**KIRKLEES METROPOLITAN COUNCIL
INVESTMENT & REGENERATION SERVICE**

| Reference No: | 2024/70/92167/W |
| Site Address: | Land off, Edgerton Road, Edgerton, Huddersfield, HD3 3AA |
| Description: | Variation of condition 1 (plans) of previous reserved matters approval 2017/90190 pursuant to outline permission 2014/93014 for erection of residential development comprising of 41 dwellings plus associated works (within a Conservation Area) |

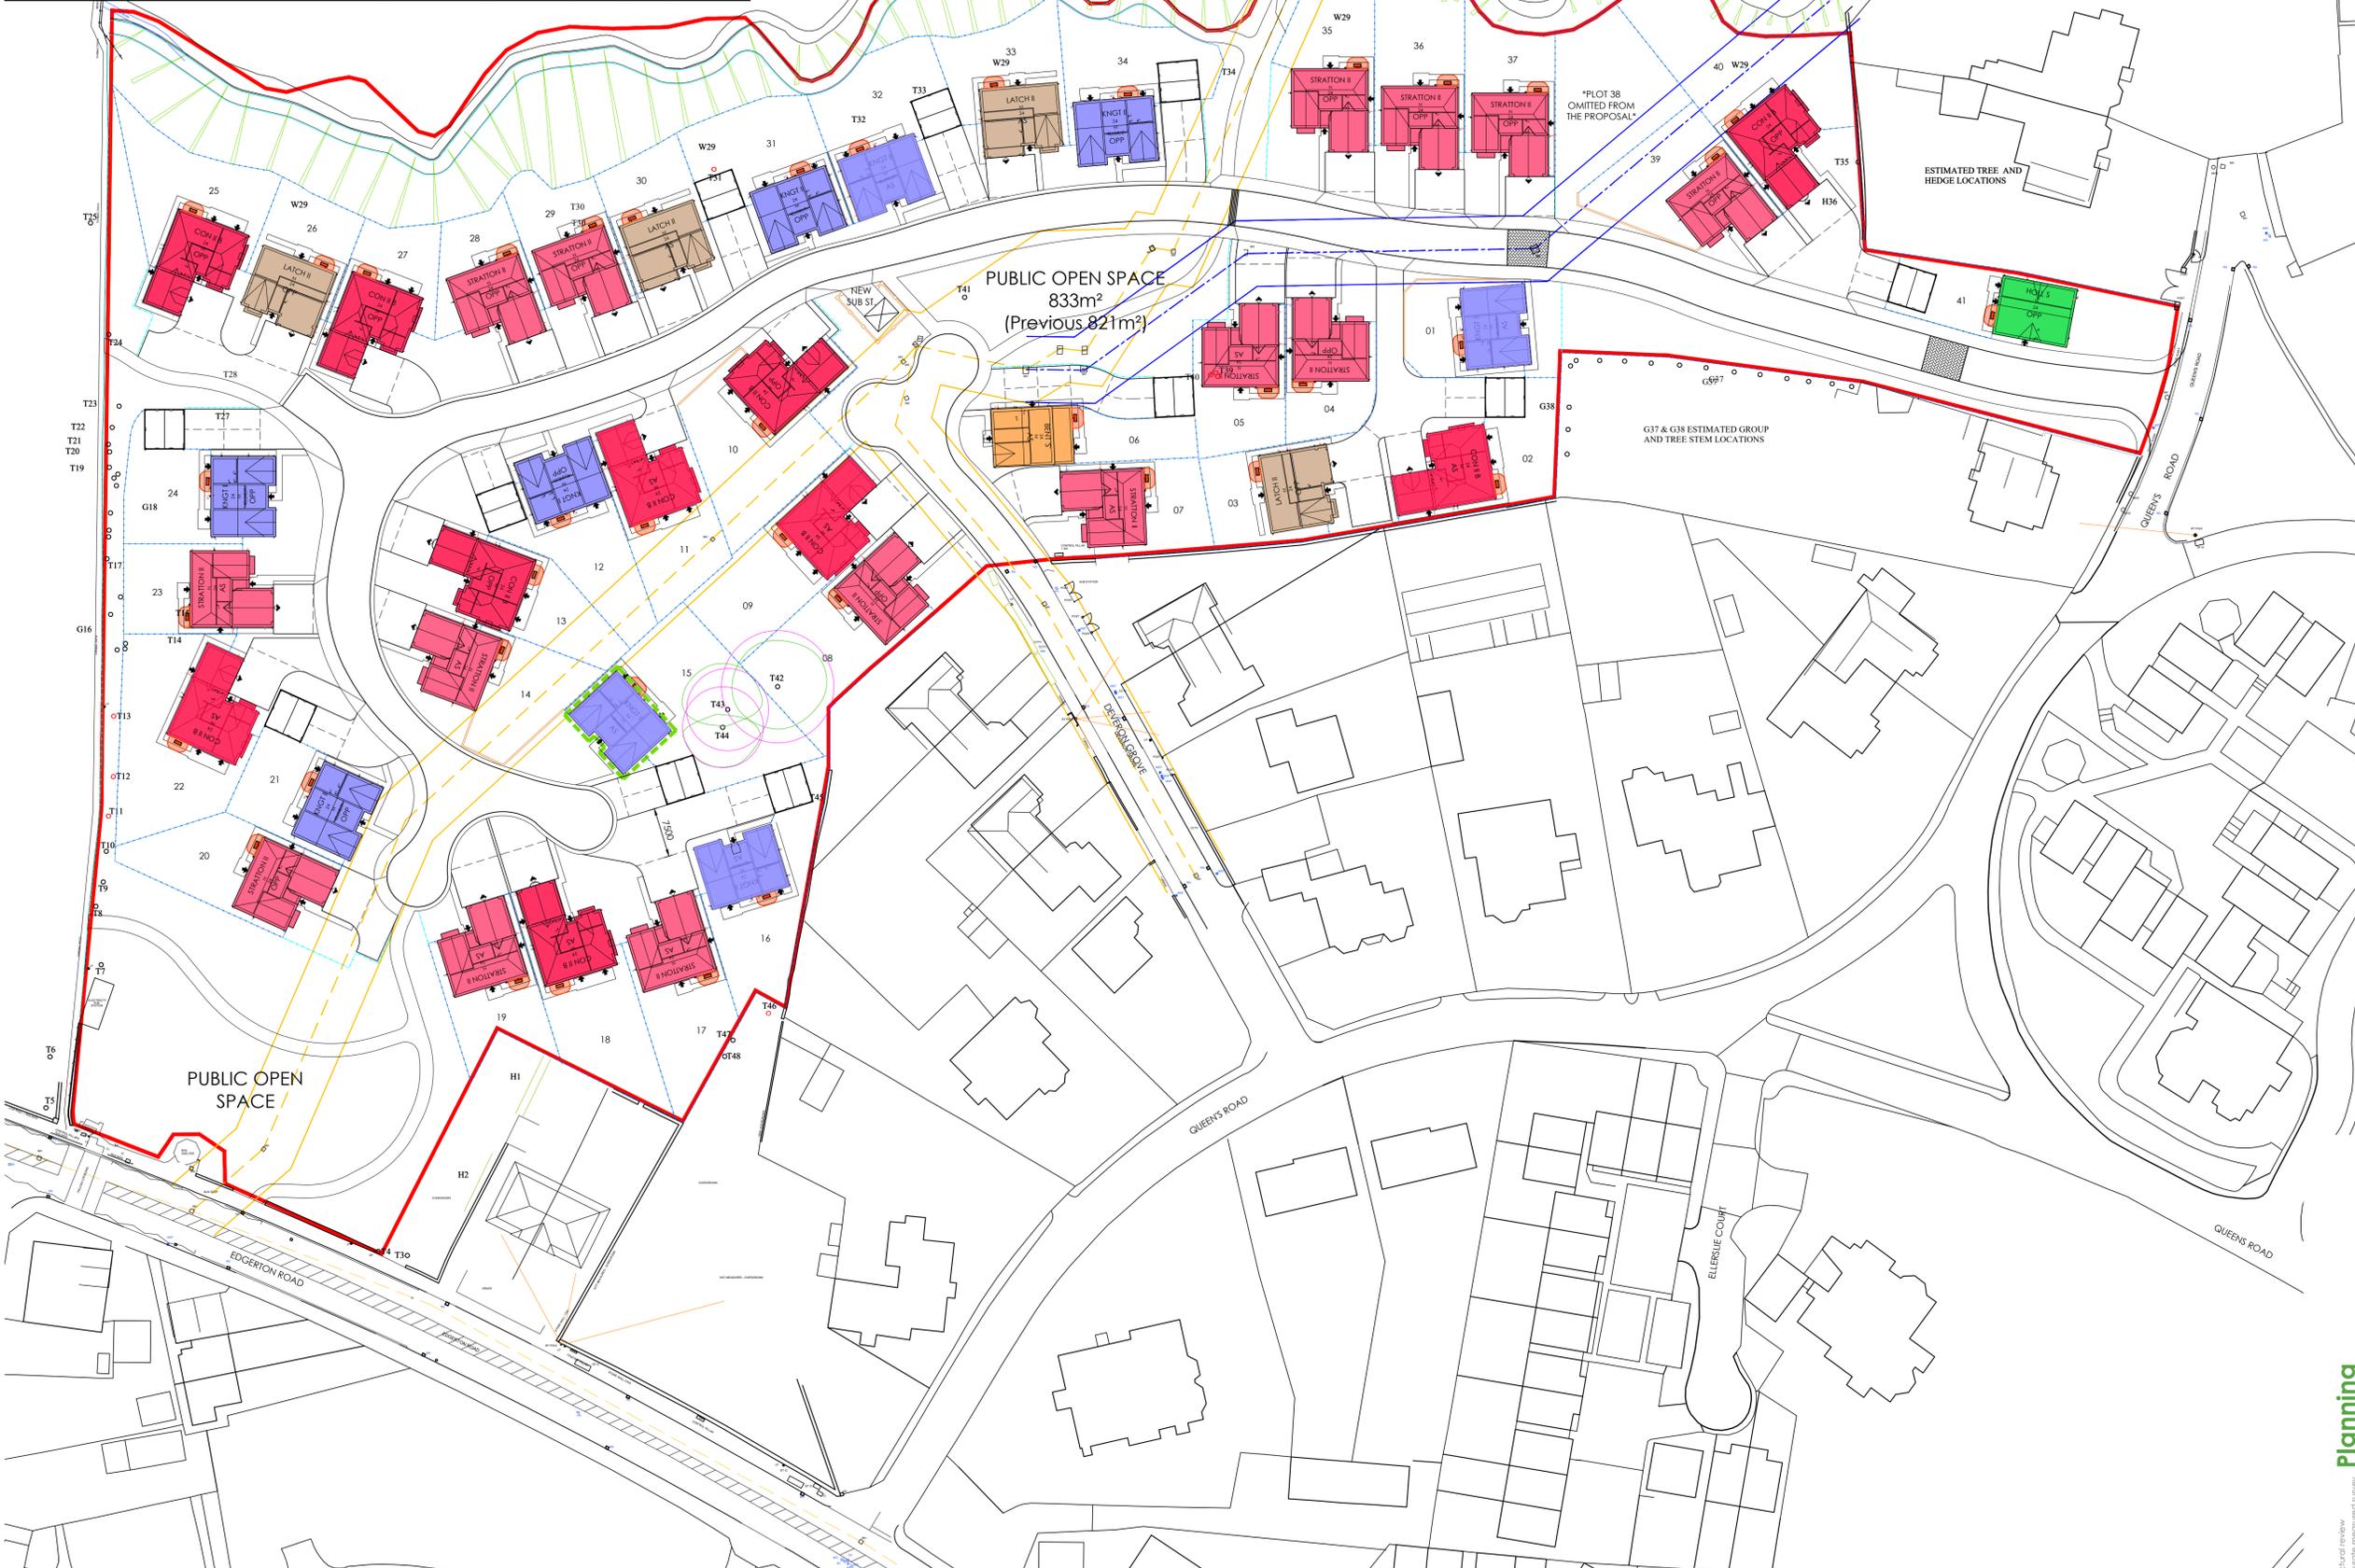
Comparing the layout of the approved and proposed plans, the differences between the two are minimal, principally being minor tweaks to the position / footprint of units (to reflect the different house types) within their plots. Officers are satisfied that there would be no material different impacts from the layout from a design perspective.

Regarding landscaping, no significant material changes are proposed. Due to the nominal layout changes, the central POS area would increase in size by 10sqm, which is welcomed. Beyond this, the proposed house-type changes and corresponding nominal layout alterations to units would not result in many changes. All trees previously intended to be retained are still to be retained and would be protected via condition 7 (compliance with the Arboricultural Method Statement) which is to be unaltered and remain in force. This would ensure that the setting of the site remains of a verdant nature, ensuring it blends well into the wider Edgerton Conservation Area. The new planting arrangements would be suitably similar that previously approved and remain at a high standard, except for to the rear of plots 20-24. As approved, this was to be turfed with three trees: as proposed, nothing is shown. This is assumed
